**Consultation Response from Mike Hibbert,
KC Waste Strategy(Refuse & Recycling)**

2022/92633 Land off, Carr Hill Road, Upper Cumberworth, Huddersfield, HD8 8XN

Demolition of store and stable block and erection of one dwelling

Responding Ref: WPN 22-46

Prop. Site
1 : 500

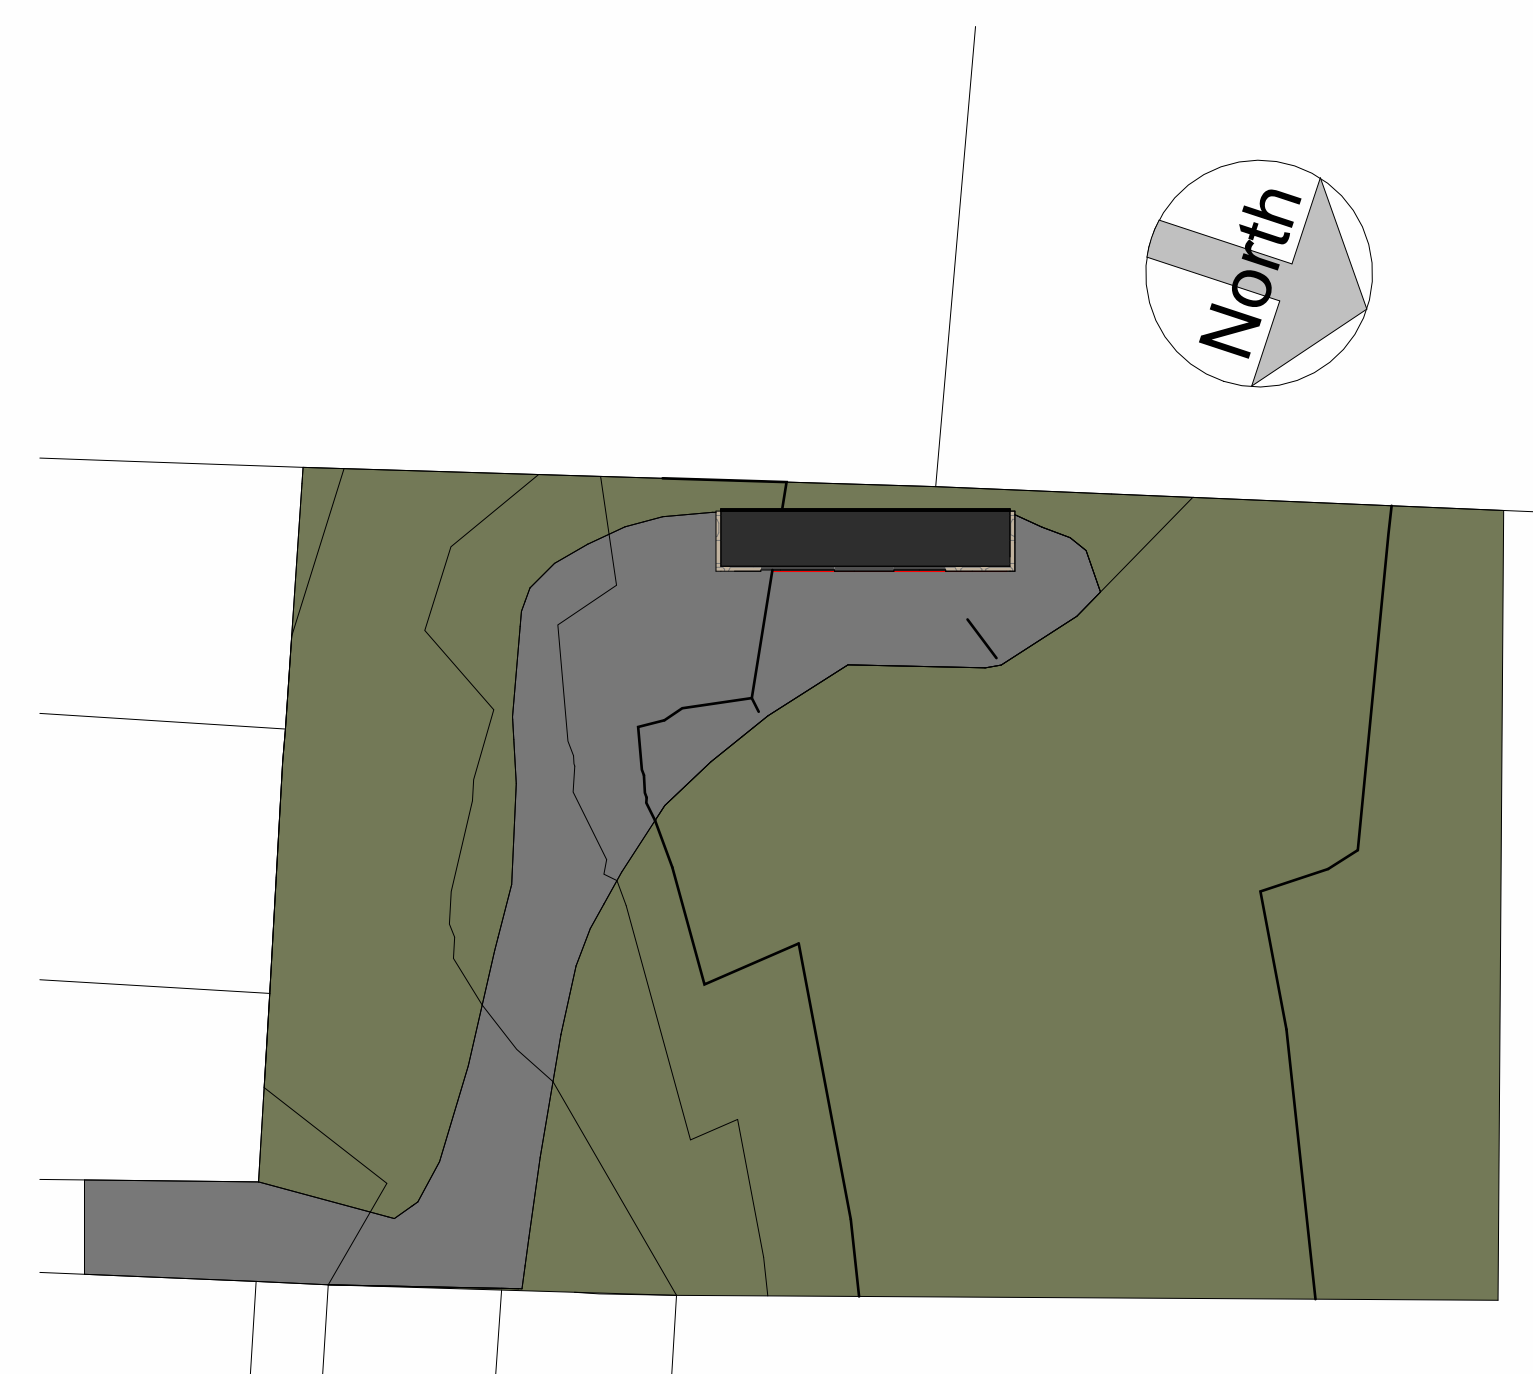
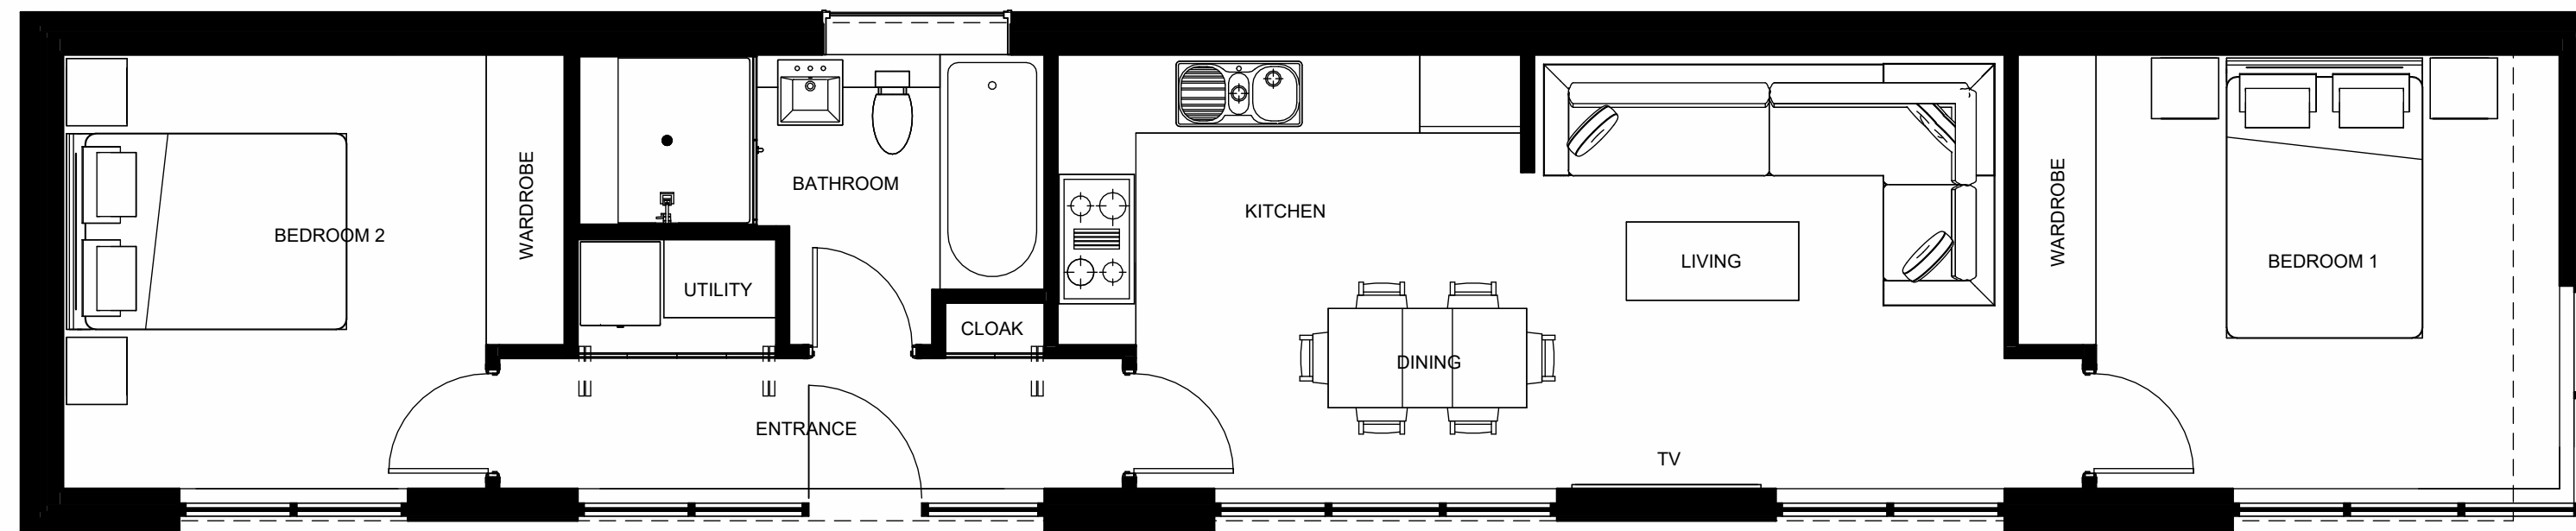
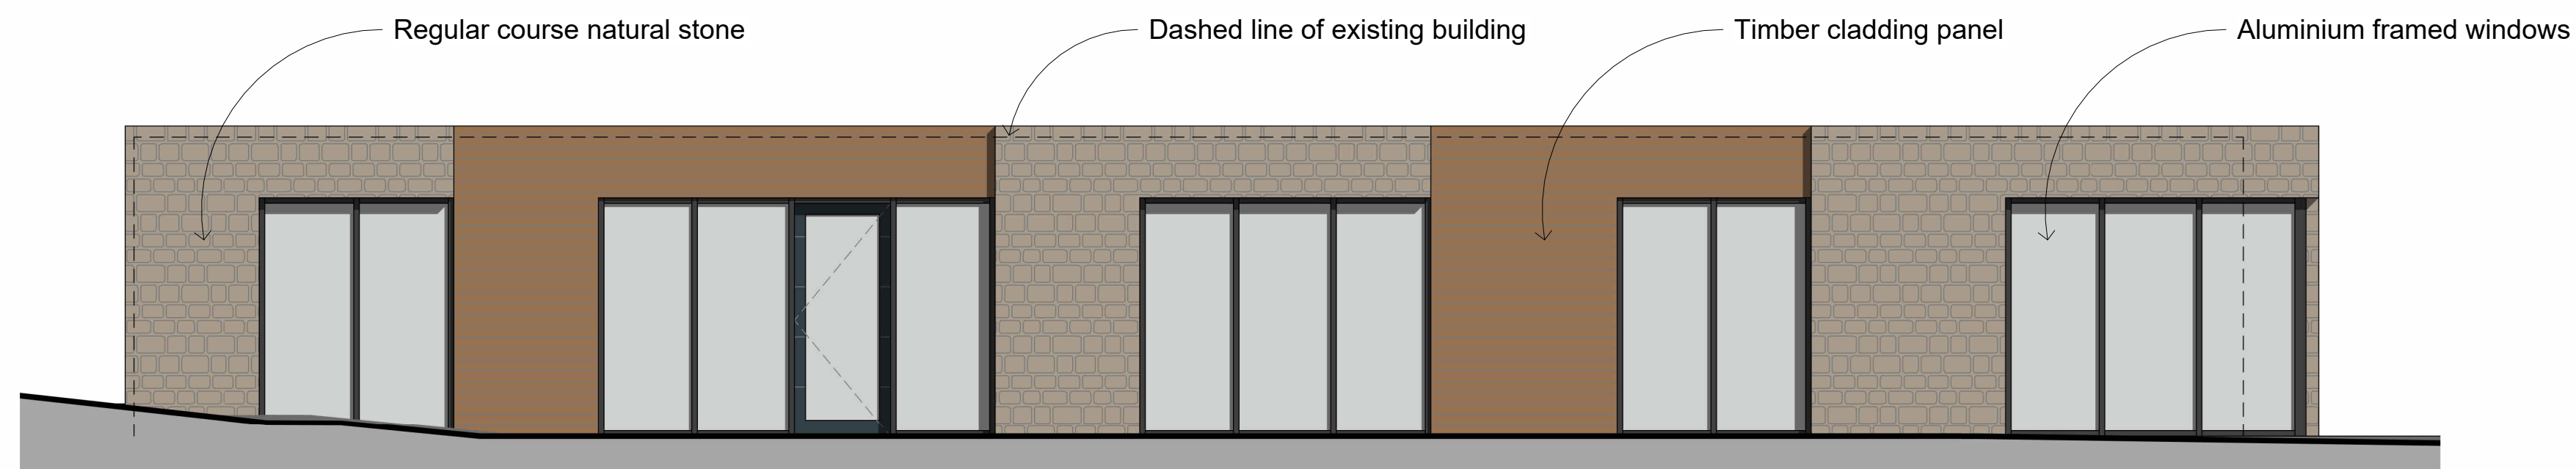
The proposed plans, elevations & 3d view ref Drawing (100)02 Dated Aug 22 does not show any details of bin storage at the proposed development. The section on waste collection and storage in the application form states "There is space for wheelie bin storage on the site, and space to store on the highway verge for collection"

- In view of the Kirklees Council waste strategy and forth coming changes to waste collection services it would be appropriate to have a bin storage area that can accommodate 3 x 240 ltrs bins, 1x240ltr Residual, 1x240ltr Recycling and as the property has a garden the space to potentially accommodate a third bin for garden waste.

- The wheeliebin storage area should be screened, secure to prevent unauthorised use, of suitable dimensions to accommodate the bins and constructed in compliance with the details specified in the design guide. The route between the bin stores and the front access road must not require residents to pull bins up/down steps or gradients of more than 1:12.

- The Authority currently collects waste generated at domestic properties on Carr Hill Road,
- The drag out distance between the proposed property and the entrance off Carr Hill Road (approximately 100m) is more than the 25m limit as specified in the Kirklees Waste Management design guide and BS5906:2005.

- RCV's will not enter private driveways unless constructed to an adoptable standard.
- For an RCV to enter the site the road layout should have a swept path analysis that demonstrates accessibility to the site for an RCV. Parked cars are a perpetual problem for RCV access and as such it is important to account for potential parking spaces, even where these are undefined, in the swept path analysis.

- If there is not access to the property for an RCV then details are required as to the dimensions, construction specification and location of a Bin Collection Point (BCP) on Carr Hill Road. Residents would be required to deliver their bins to a presentation point for collection.
